**PLANNING AND INFRASTRUCTURE**  
Planning Unit

Re: State Significant Development Application Number SSD-76555711  
Mixed use infill affordable housing: 3-5 Help Street, Chatswood  
Response to Submissions

Appendix D

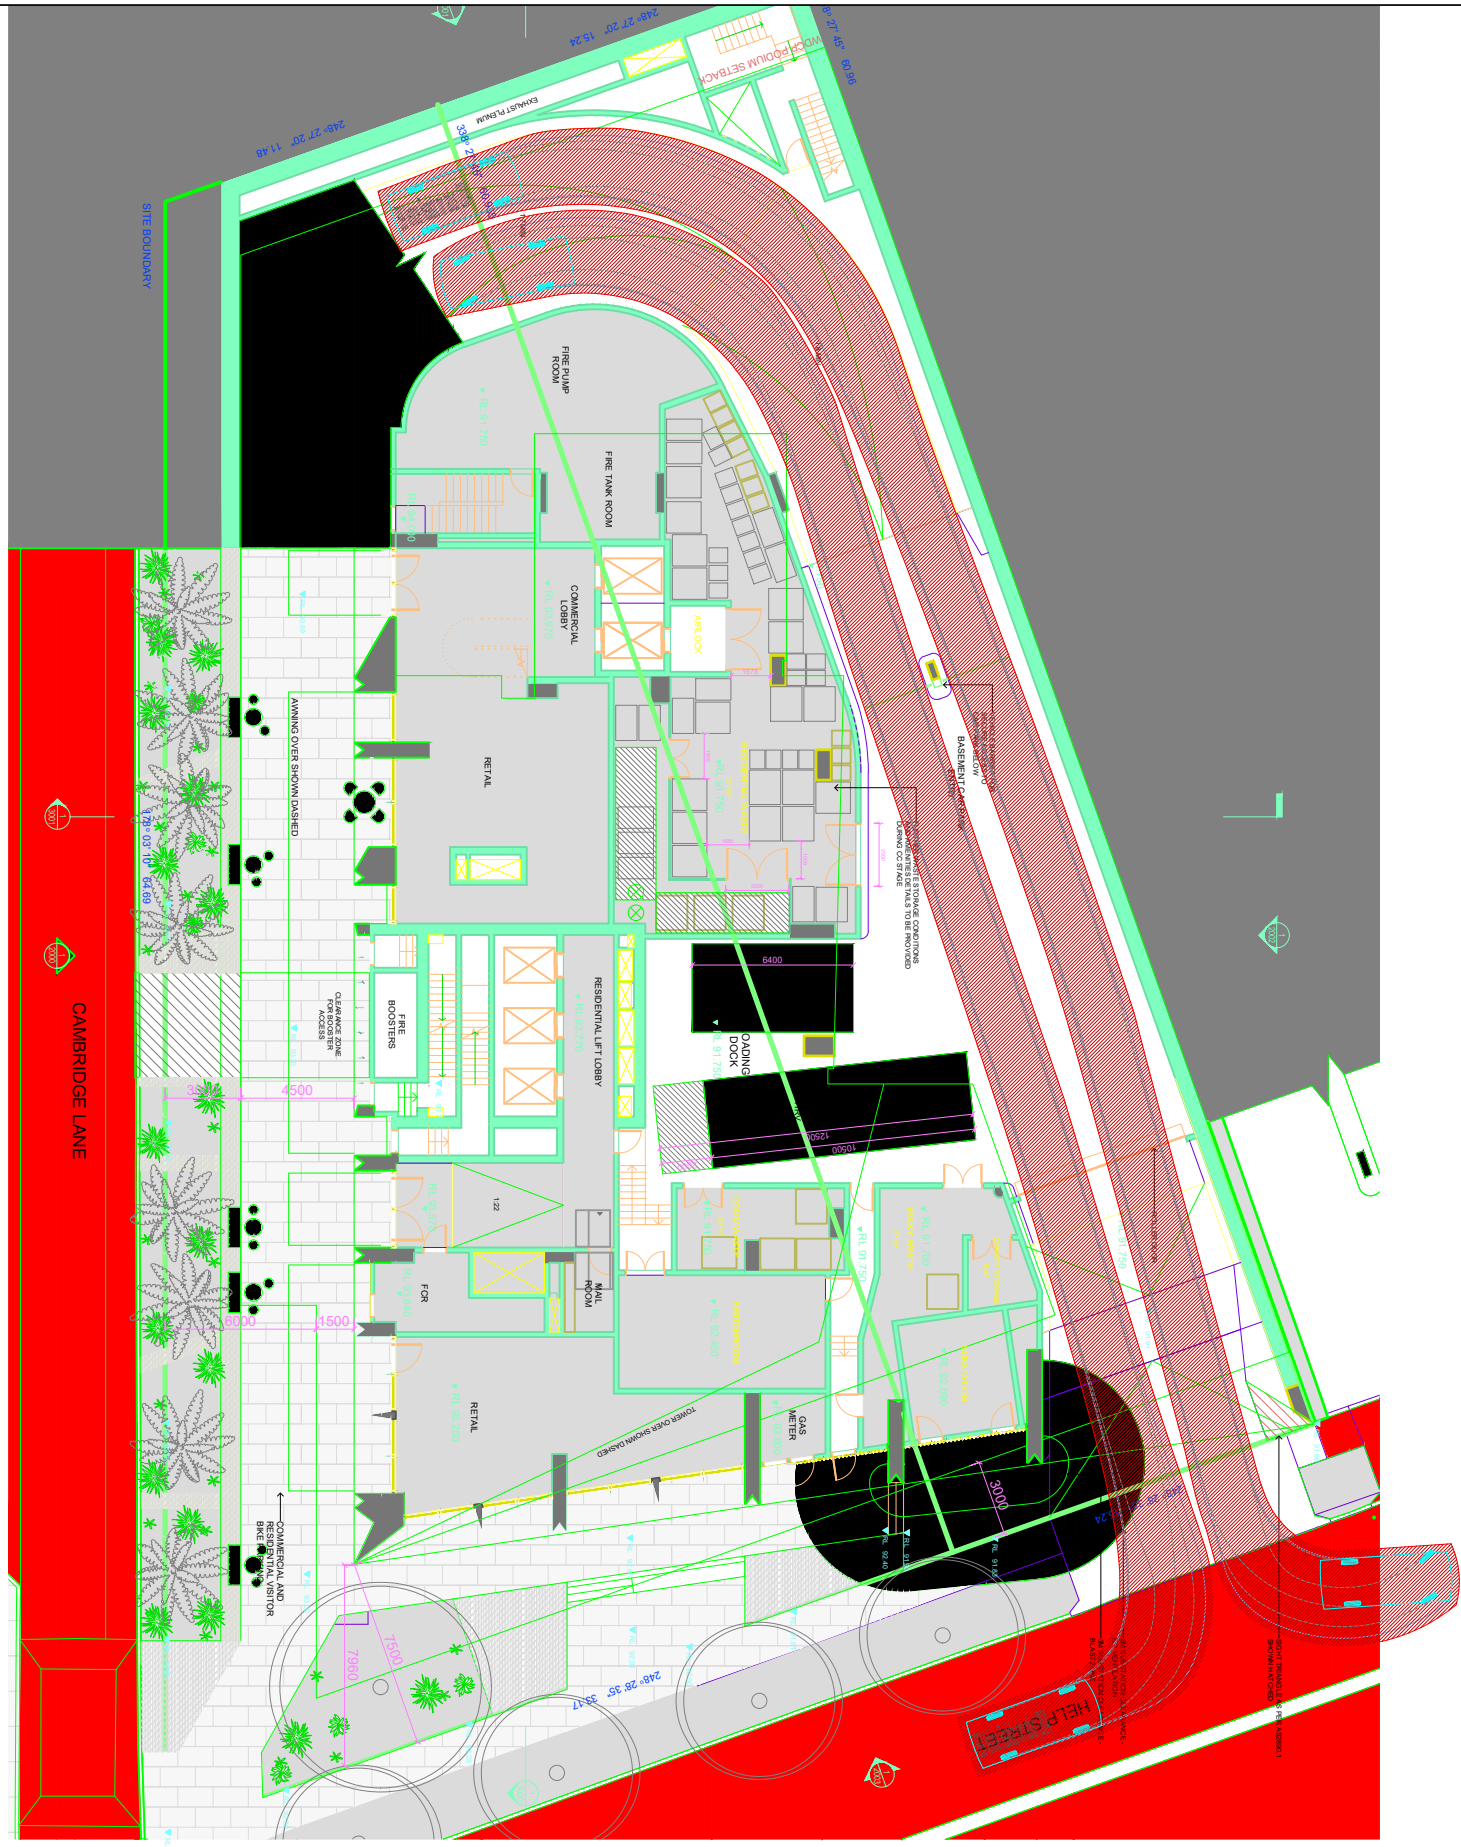
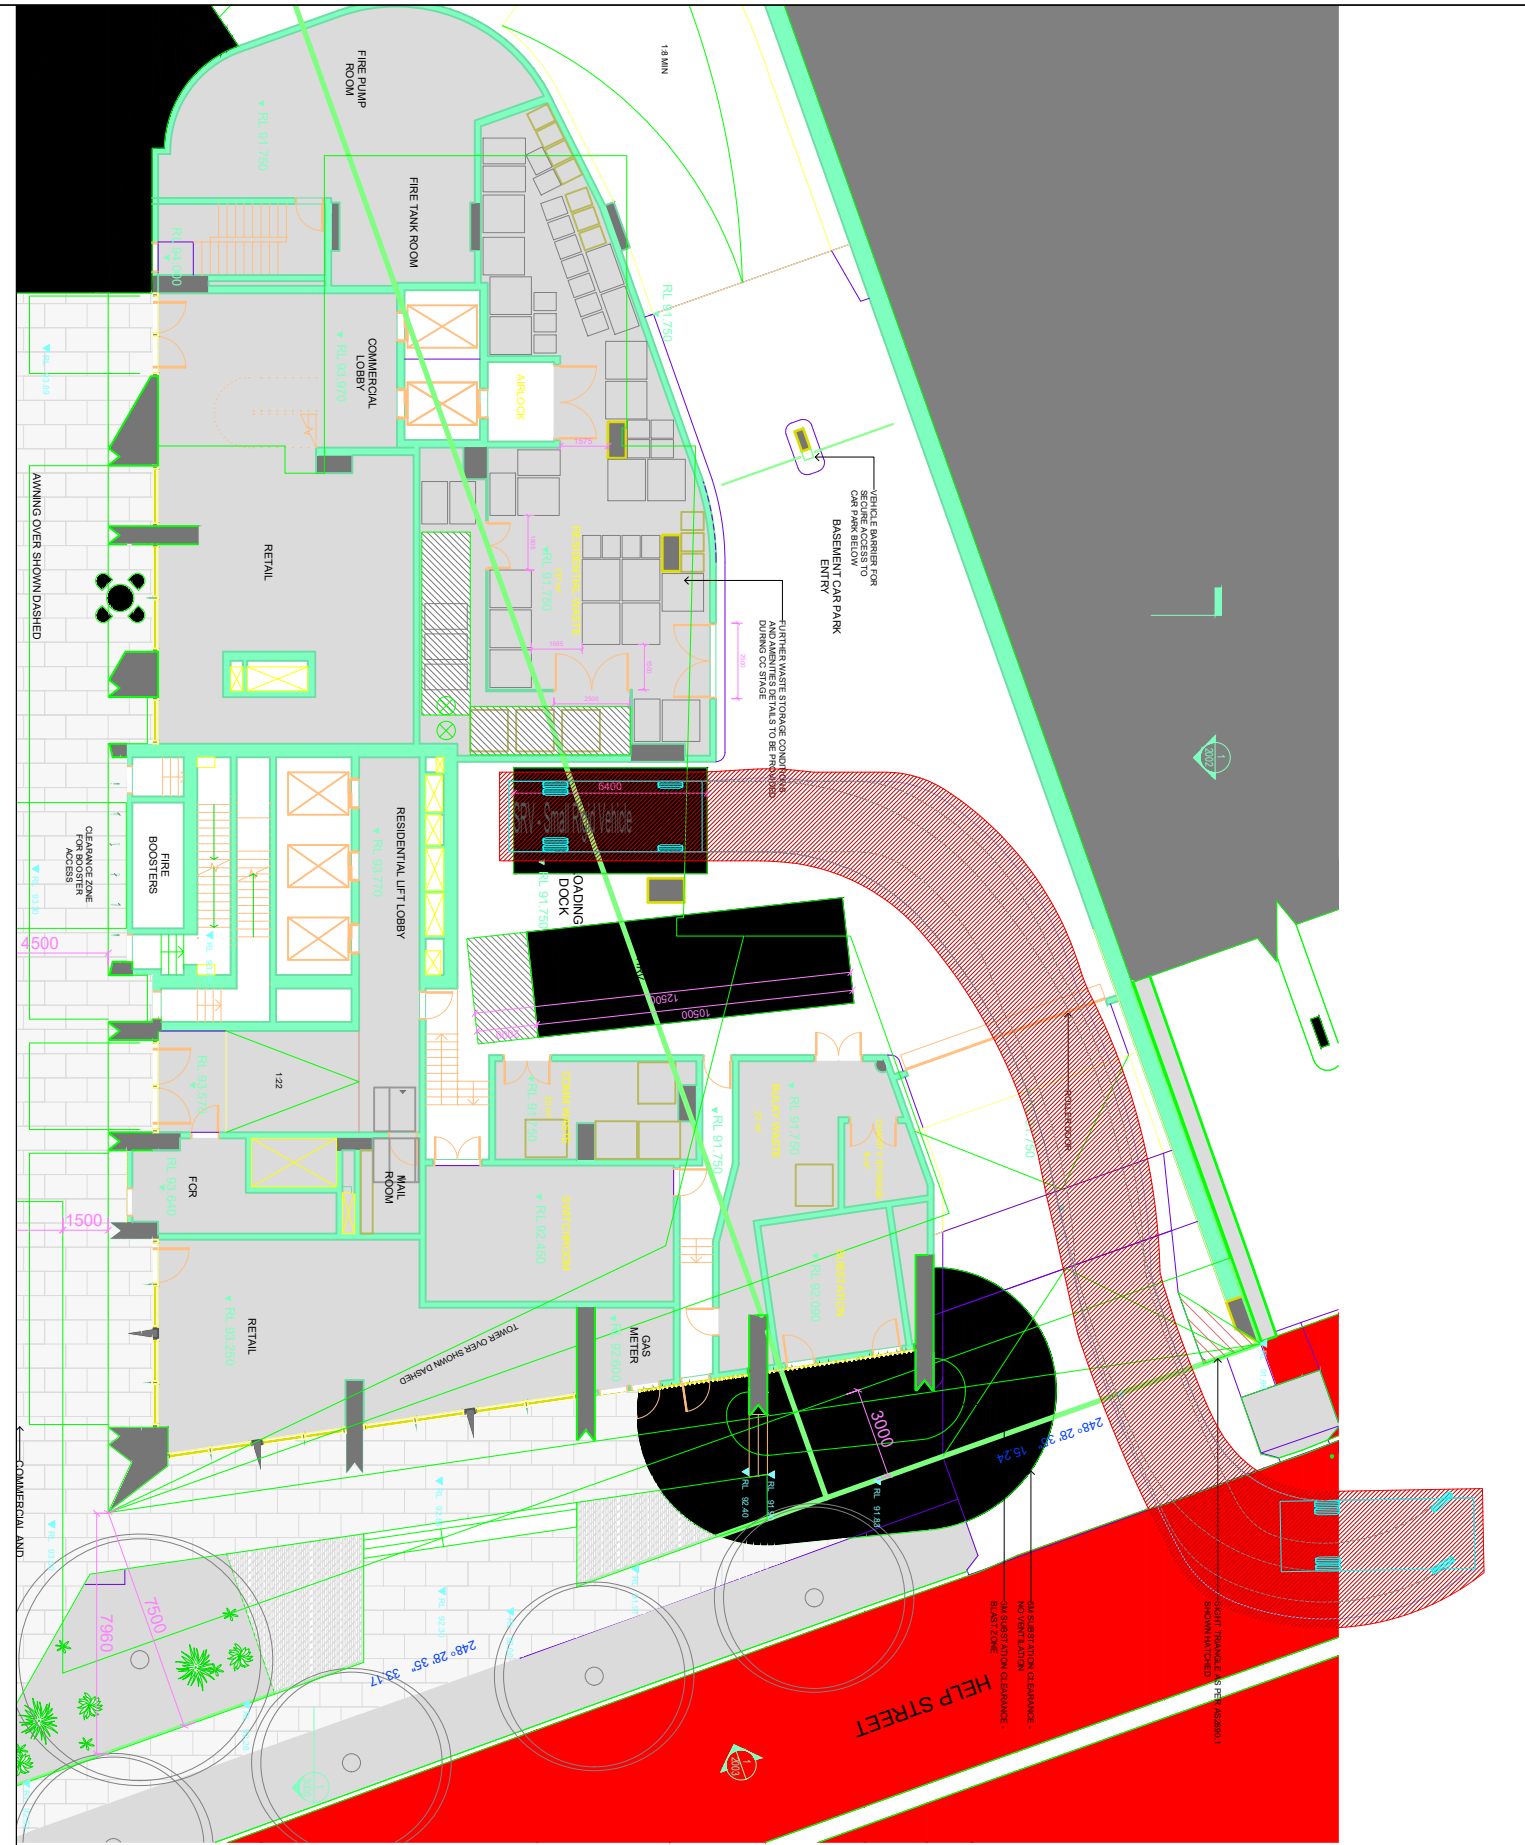
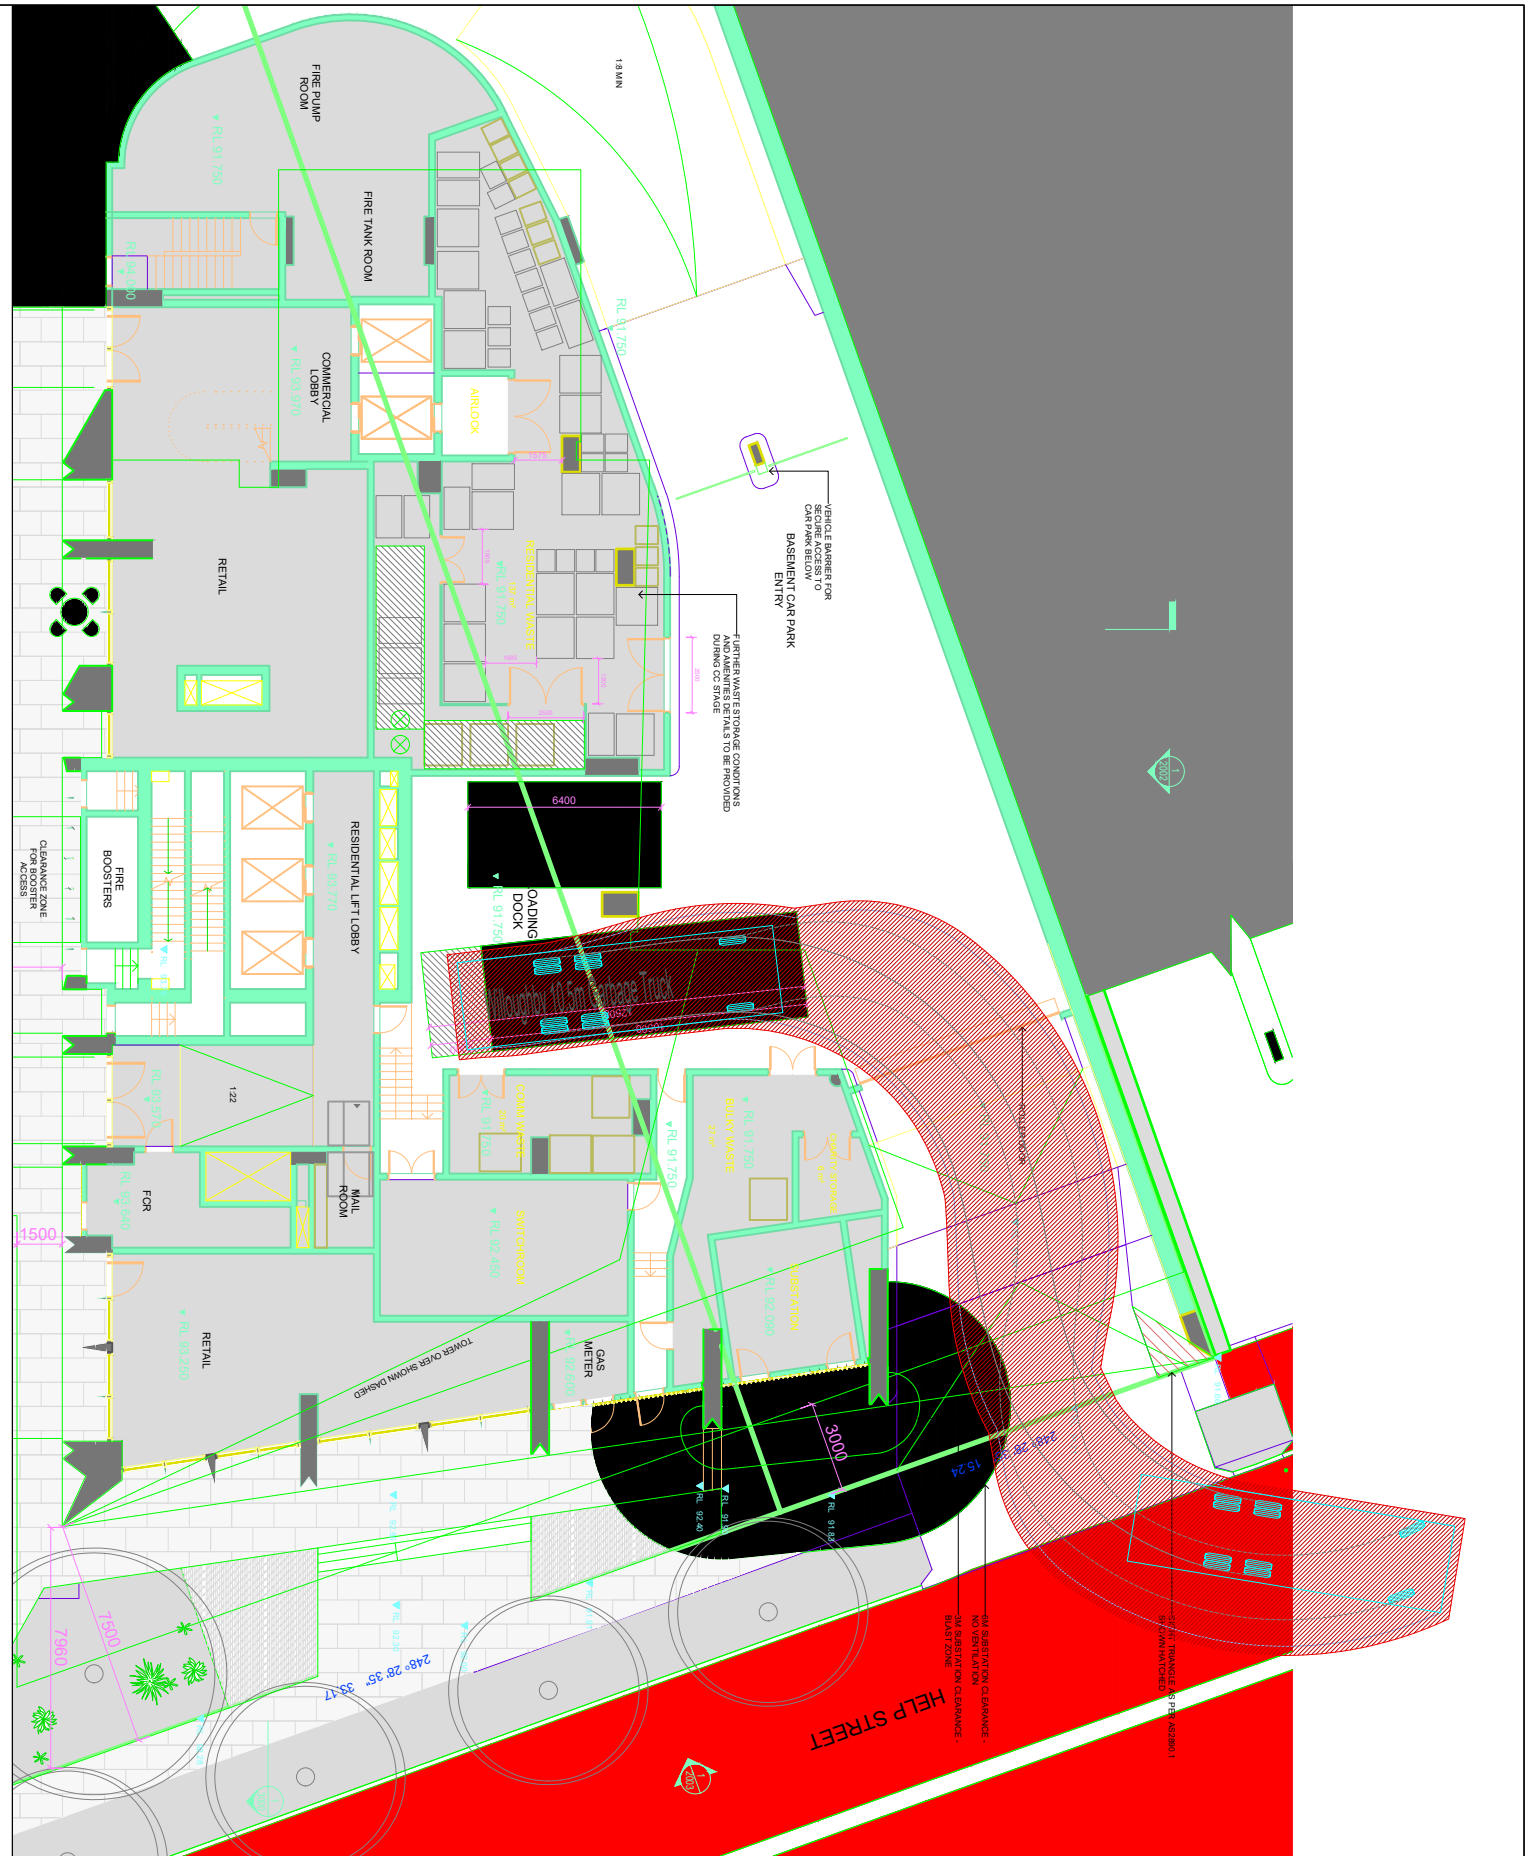
Willoughby City Council has developed a schematic design for the works that will be required to ensure vehicles, including waste and delivery vehicles are able to safely access the site, noting the current intersection of Help Street and Cambridge Lane, and the current configuration of Cambridge Lane and of McIntosh Street require upgrades to accommodate the proposal and avoid dangerous conflicts between vehicles, cyclists and pedestrians.

Cambridge Lane, and its intersection with Help Street, is required to be upgraded to more safely accommodate larger vehicles, and remove conflicts with cyclists.

The development should be conditioned to provide public domain upgrades to Council's satisfaction, upgrading Cambridge Lane, including its entry point from Help Street, and implementing the no right turn arrangements specified above.

*Construction Plans for Public Domain Upgrades are to be approved by Council prior to the issue of a Construction Certificate. The works should include, to Council's specification, raised thresholds, road paving, landscaping and signage upgrading of McIntosh Street, Help Street and Cambridge Lane. Cambridge Lane and McIntosh Street are to be a shared zones.*

*Public Domain Upgrades on McIntosh Street, Help Street and Cambridge Lane are to be constructed to Council's satisfaction prior to the issue of an Occupation Certificate.*
